**Planning Department
Transportation Development Services**

Re: Glenrio Apartments, Glenrio Rd NW & I-25
Submittal for Certificate of Occupancy – Transportation Development
Architect's Stamp dated 10-09-13 (J10D043)
Certification dated 12-16-14

The Letter of Certification submitted on 12-16-14 is not sufficient for acceptance by this office for final Certificate of Occupancy (C.O.). The following items need to be addressed:

TRAFFIC
CIRCULATION LAYOUT

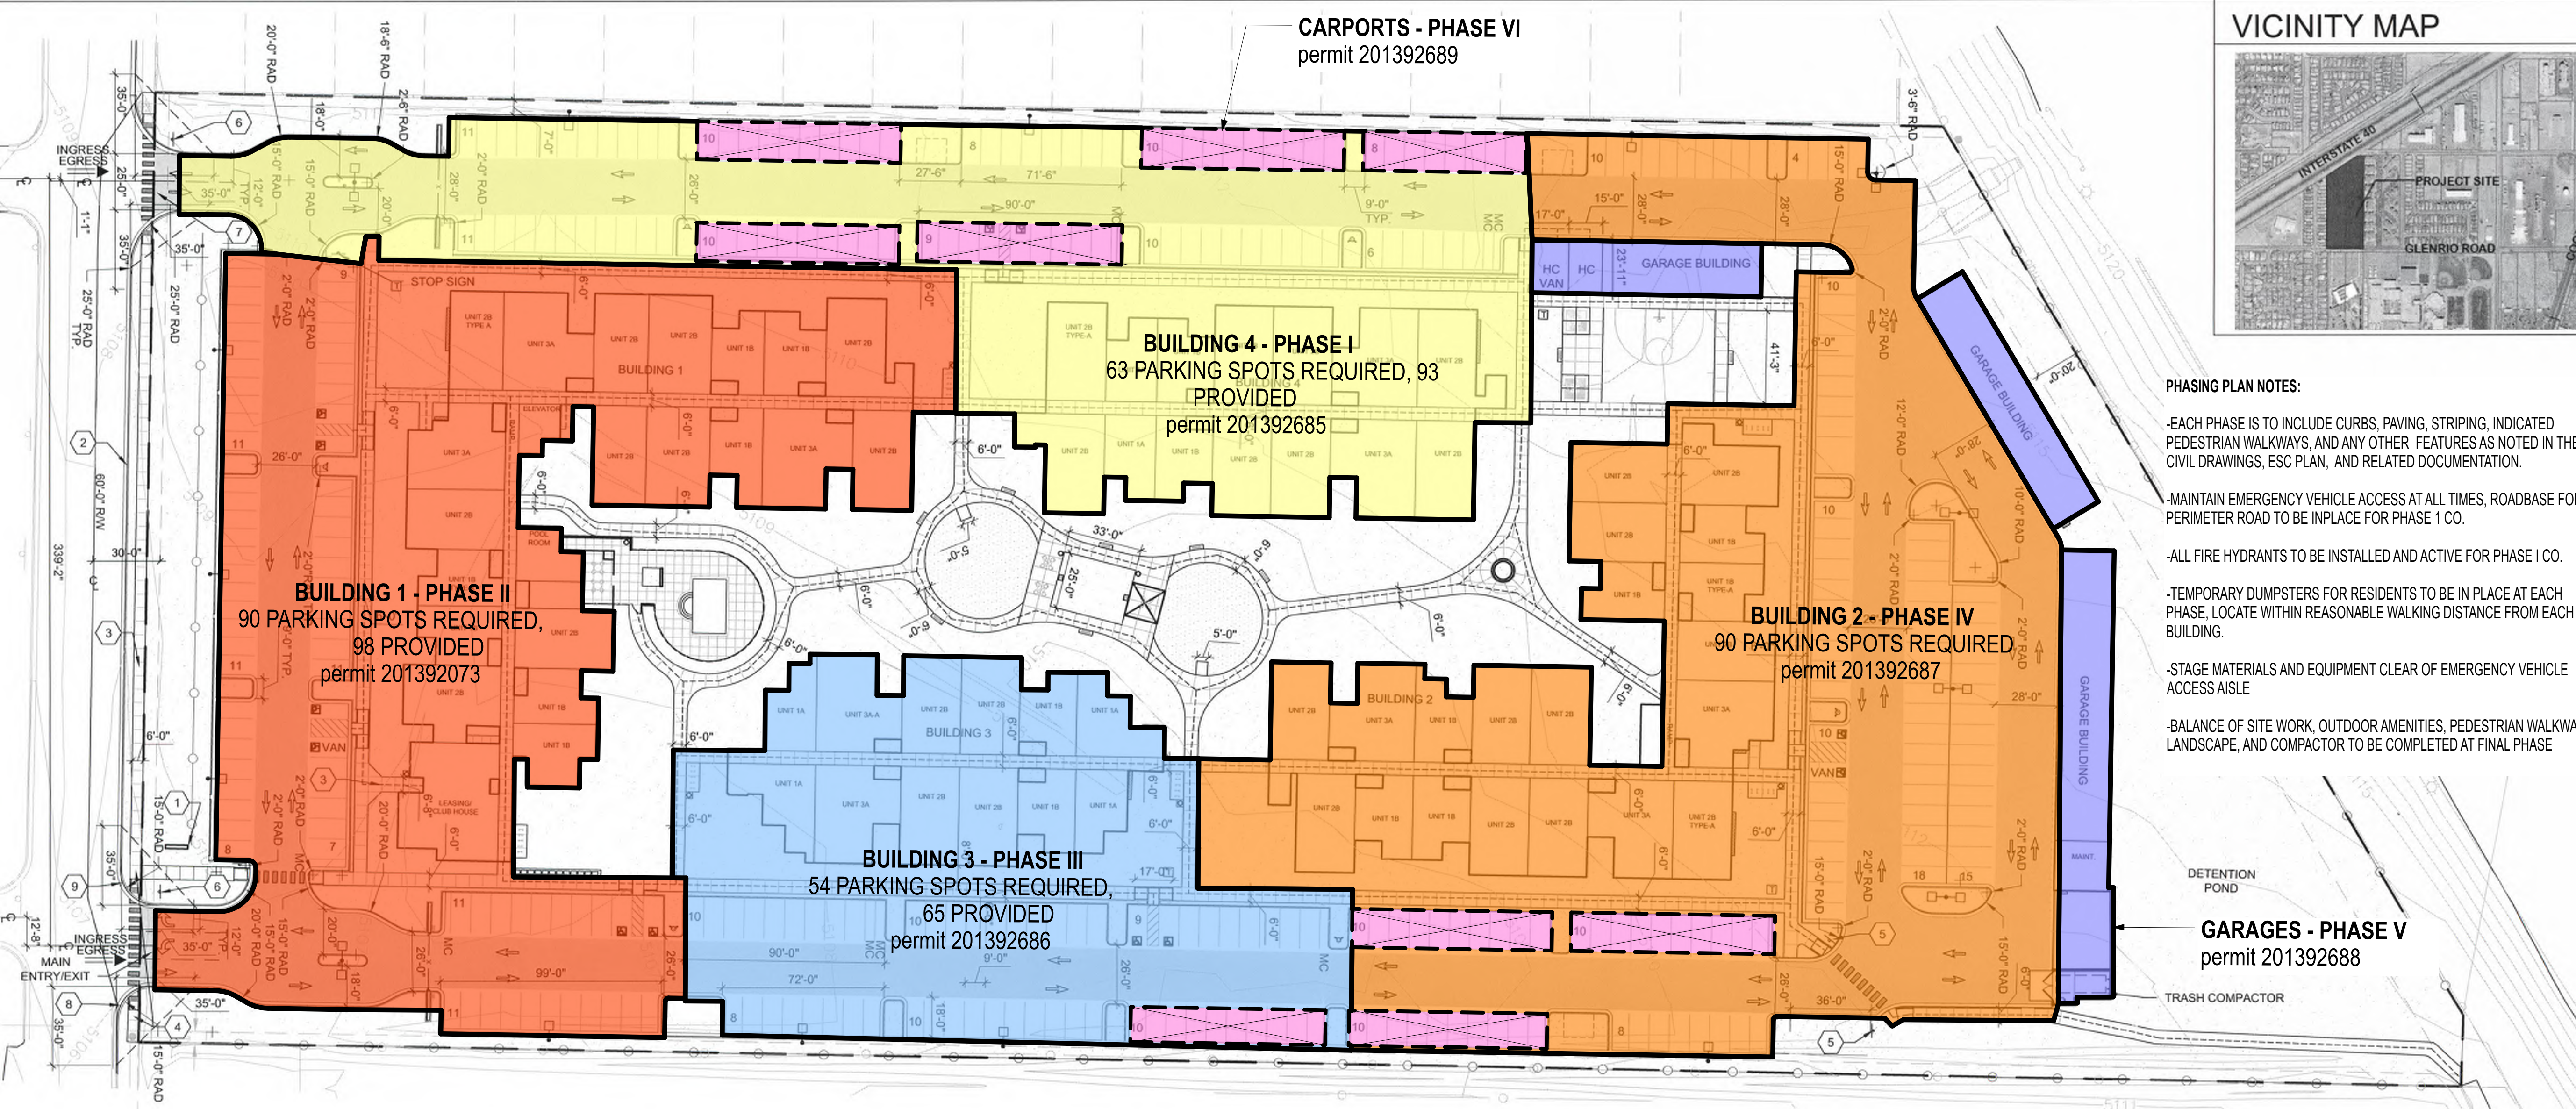
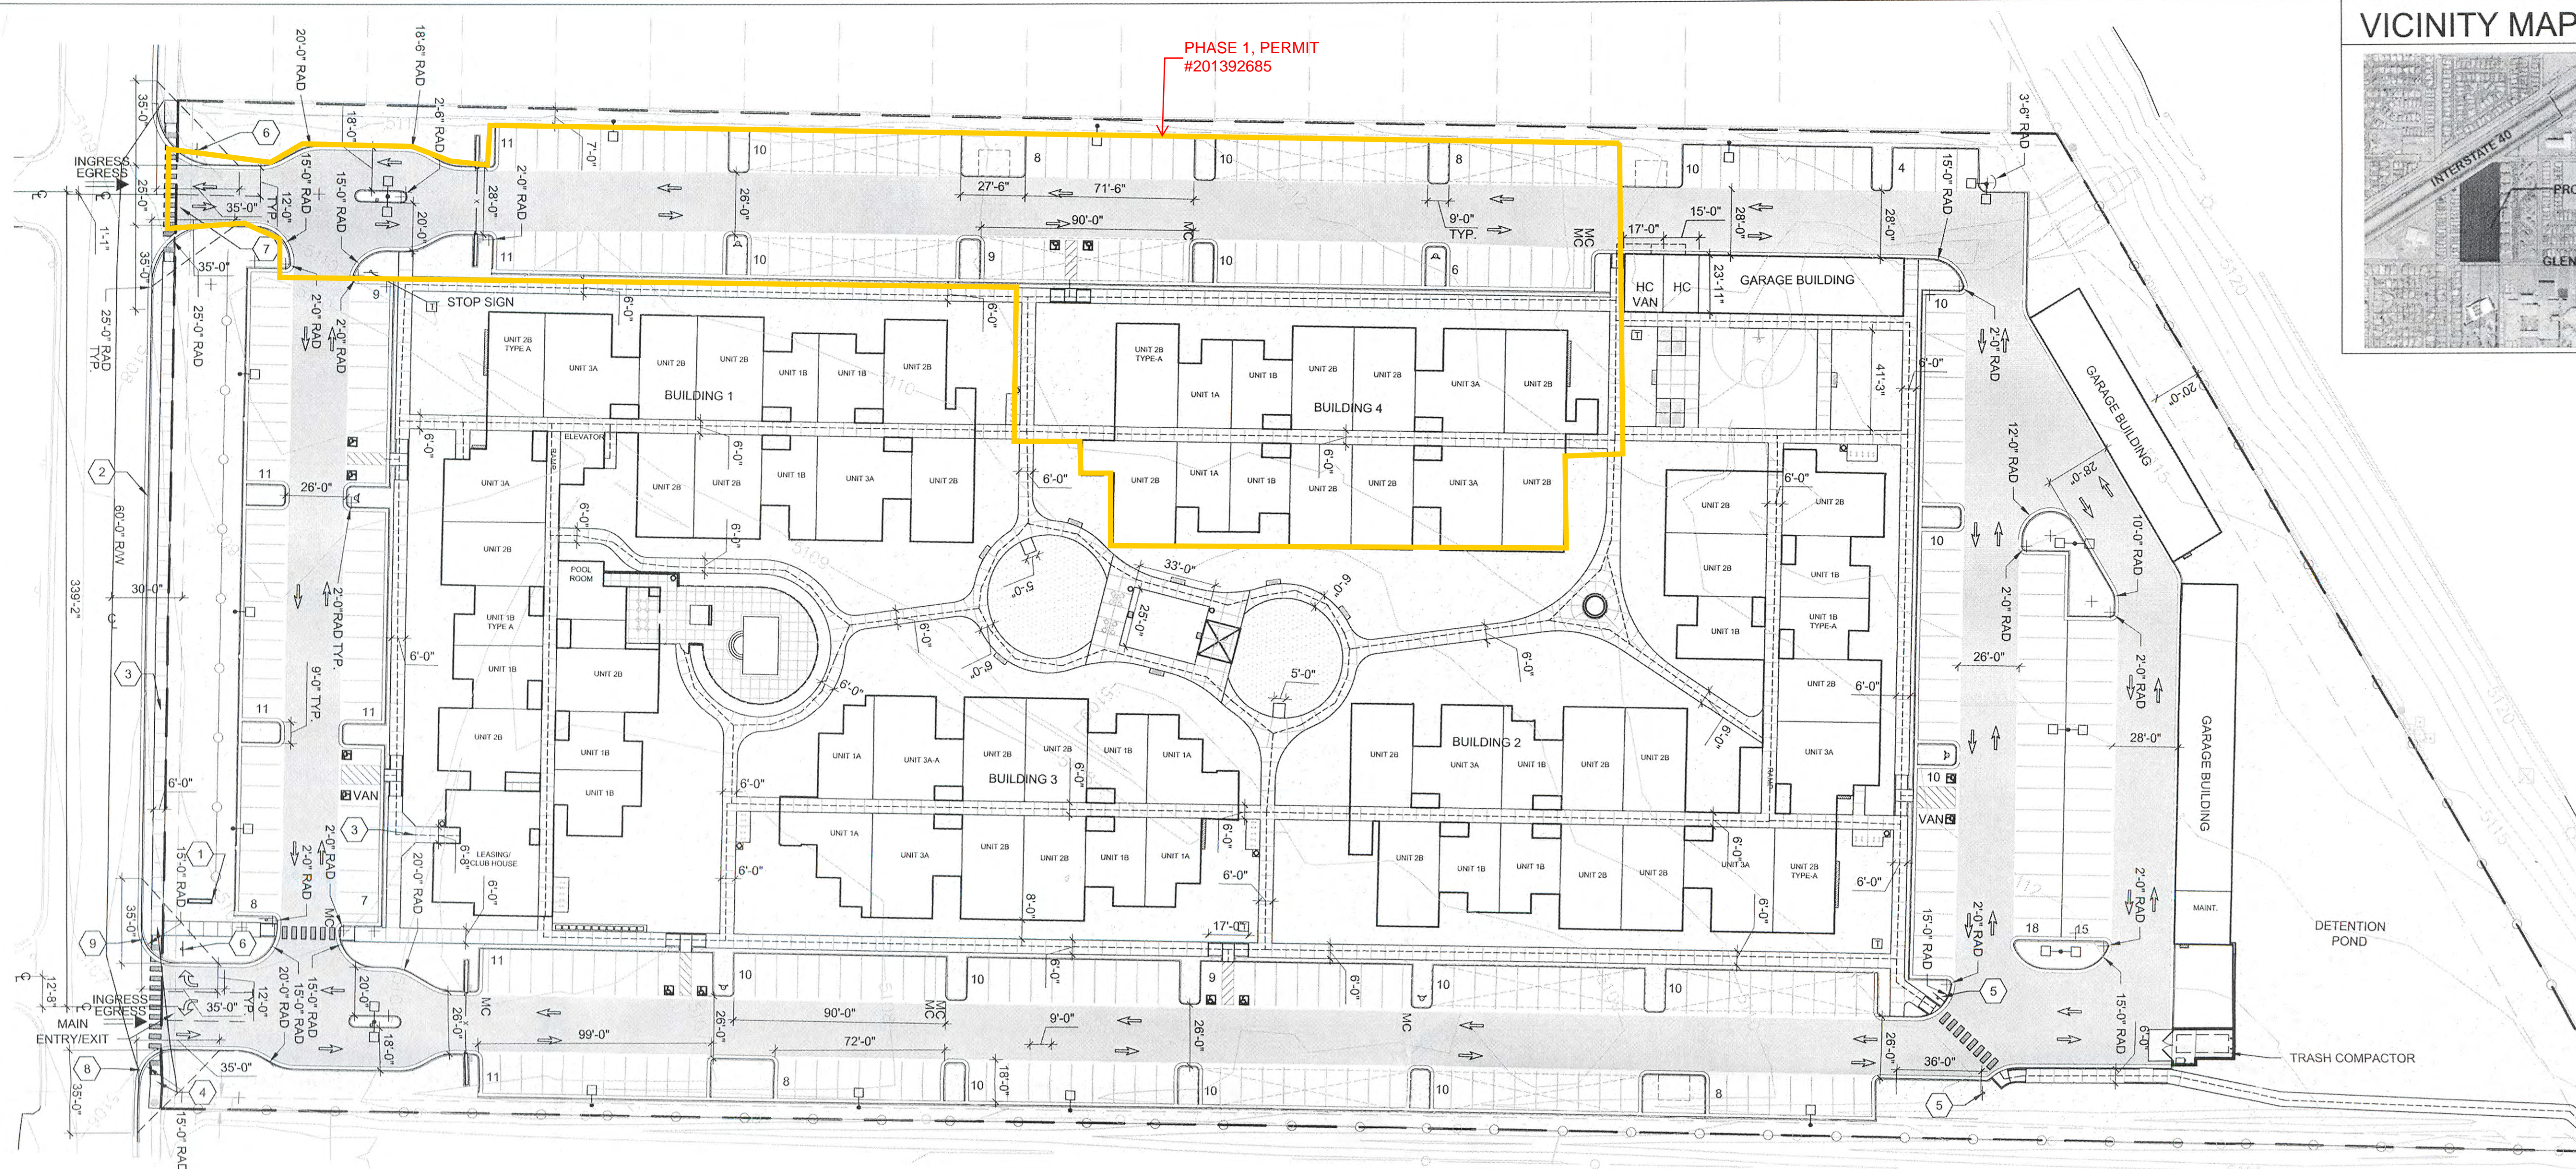
- All sidewalk culverts along Glenrio Rd NW need to be placed prior to release of Certificate of Occupancy.
- All curb and gutter along Glenrio Rd NW need to be placed prior to release of Certificate of Occupancy.
- Water has seeped under the truncated dome causing it to loosen at the west entrance on Glenrio and will need to be replaced.
- All City of Albuquerque right of way along Glenrio Rd NW needs to be free of all tripping hazards.
